Application No: A/169/21/PL
Site Address: Land South Of Littlehampton Road and East of Worthing Road Angmering BN12 6PN
Description of works: Construction of a new access to serve existing agricultural use and proposed residential development. This site is in CIL Zone 5 and is Zero rated as other development. This application is a Departure from the Development Plan.

Thank you for your internet representation made on 26th August 2021 which has been recorded as an objection with the comments as follows:

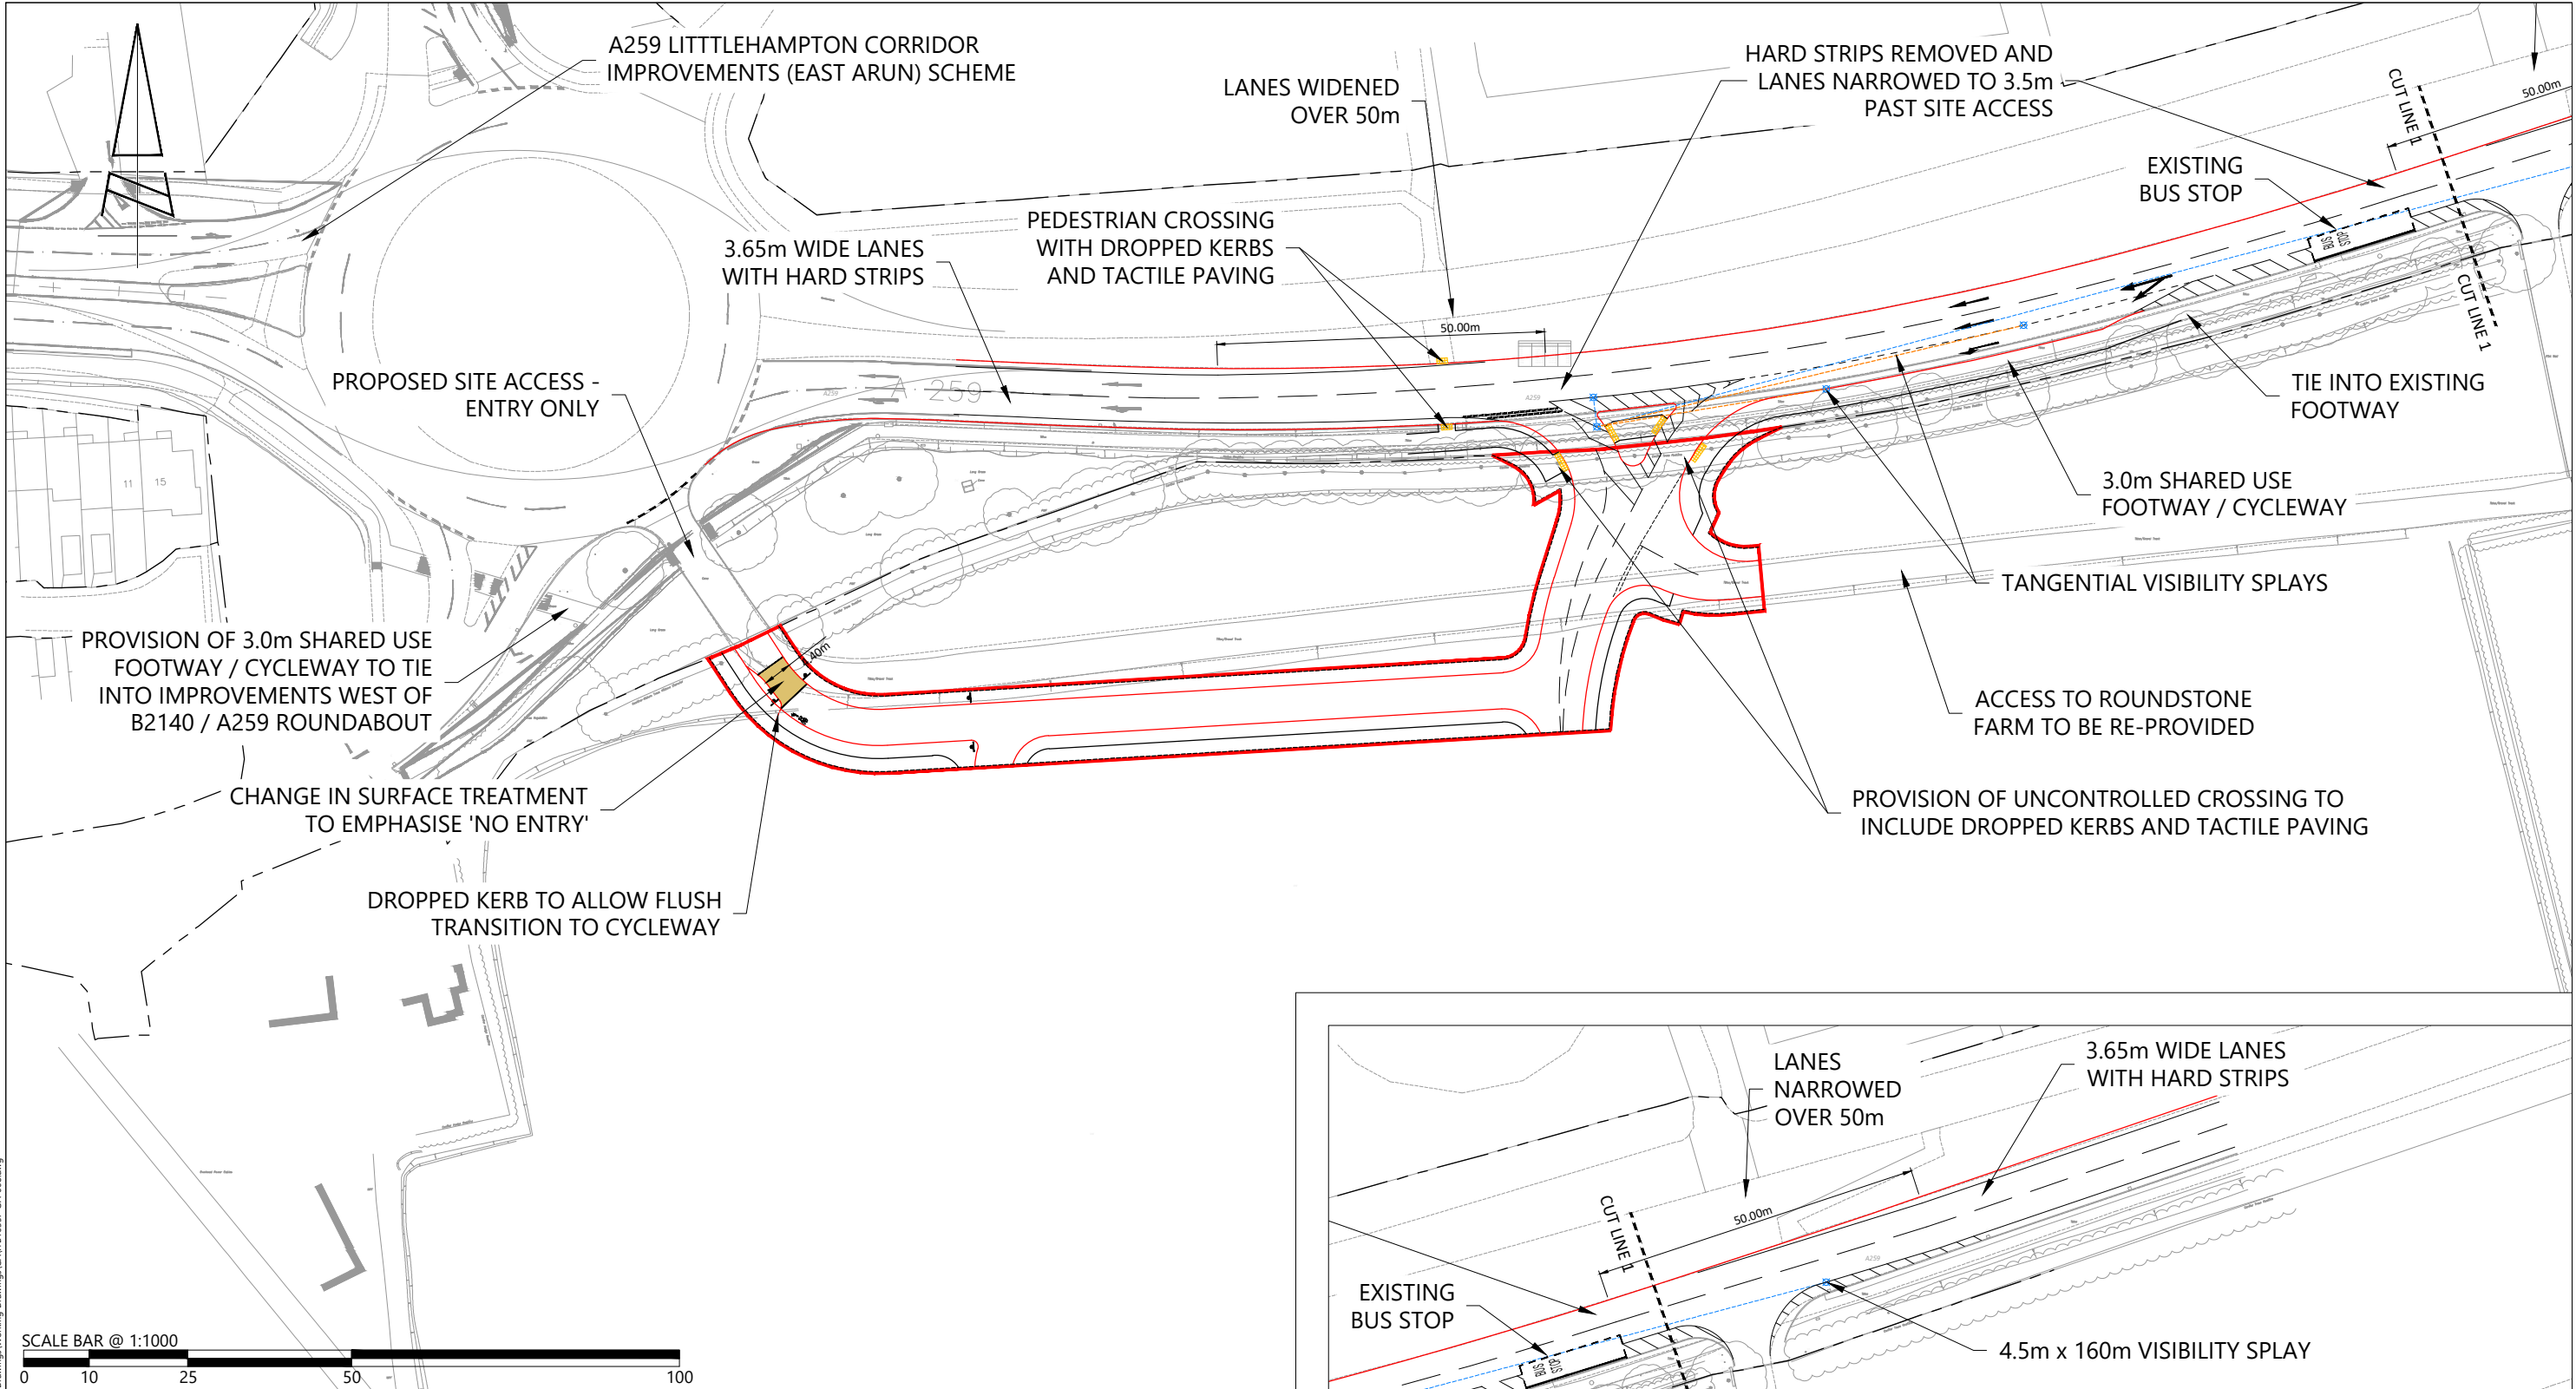
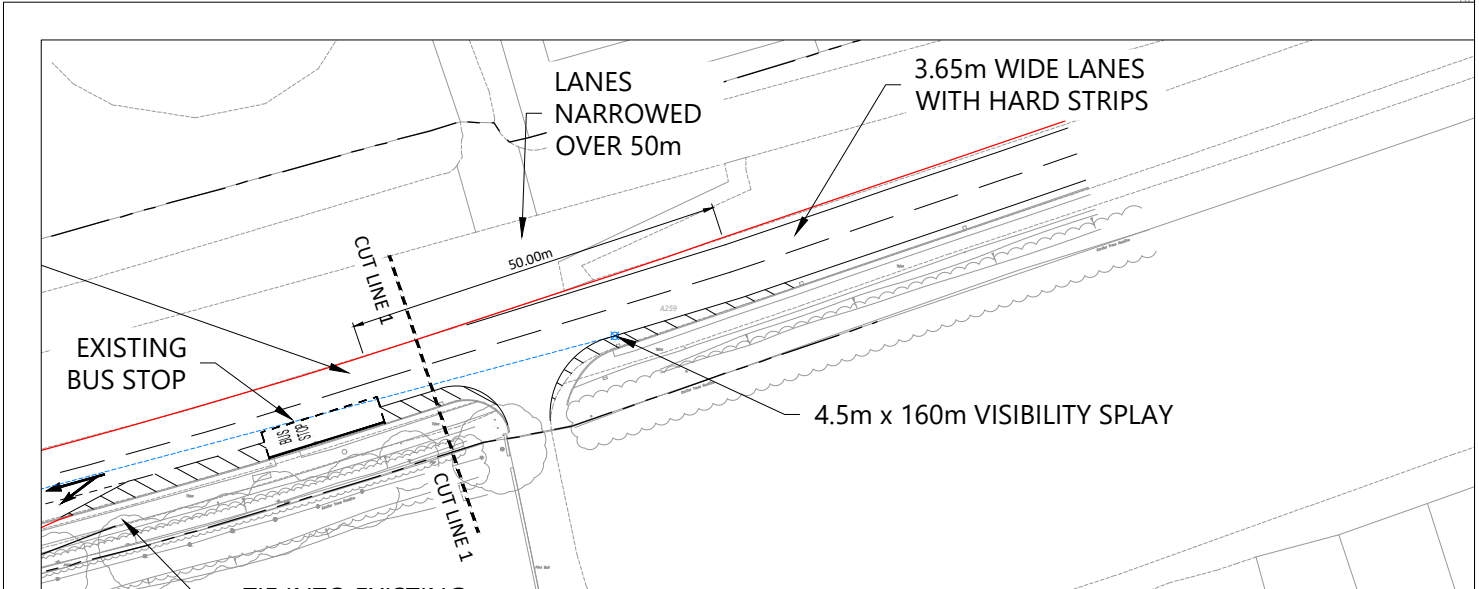
The proposed new access is a departure from the Development Plan so should be refused.

The application is by Redrow Homes. It has nothing to do with serving the existing agricultural use, it is purely to provide access to the proposed housing development (planning application (A/168/21/PL). Redrow Homes want to provide access from the roundabout so that anyone approaching from the west has access to the proposed housing development without having to go to the Asda junction or the A259/A2032/Titnore Lane roundabout and doubling back. This application is purely about the proposed Redrow Homes development.

Providing an access off the roundabout which is so close to the access to the roundabout from the A259 would be dangerous. It will also result in more congestion on a very busy roundabout.
